WEST SUSSEX COUNTY COUNCIL
HIGHWAYS AND TRANSPORT SERVICES CONSULTATION

SUBJECT: AL/26/08/ - Outline application for new dwelling alongside 10 Lidsey Road with all matters reserved

10, Lidsey Road, Woodgate, Aldingbourne, West Sussex

RECOMMENDATION:

Drawing OP02 Feb 2008 Scale 1:500 / 1:1250  
Block Plan and Location Plan

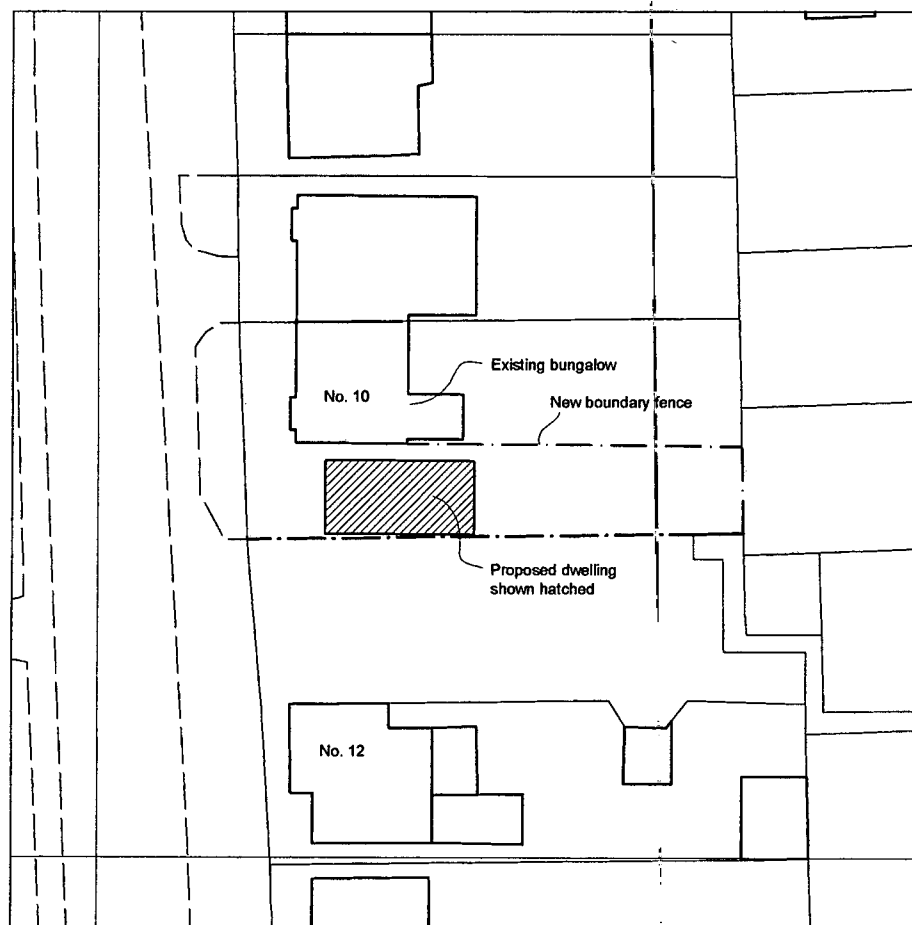
The proposal is for a single dwelling unit with access onto Lidsey Road via an existing access point. This proposal has been considered using drawing no. OP/02 submitted with this application, in conjunction with other available map information. A site visit can be arranged on request.

From an inspection of the plans alone, there is no apparent visibility issue at the point of access onto Lidsey Road. I have also checked our most recently available verified accident records, which reveals there have been no personal injury accidents in the vicinity of the existing point of access, indicating a low risk of highway safety issues with this proposal. Secure and covered cycle parking should be included if this application obtained planning permission.

No dwelling, hereby approved, shall be occupied until covered secure cycle parking spaces have been provided in accordance with a detailed construction plan to be submitted to and approved by the planning authority.

No works shall be carried out on site unless provision is available within the site (or other adjacent land within the applicants control) in accordance with details approved by the Local Planning Authority, for all temporary contractors buildings, plant and stacks of materials associated with the development and such provision shall be retained for these purposes throughout the period of work on the site.
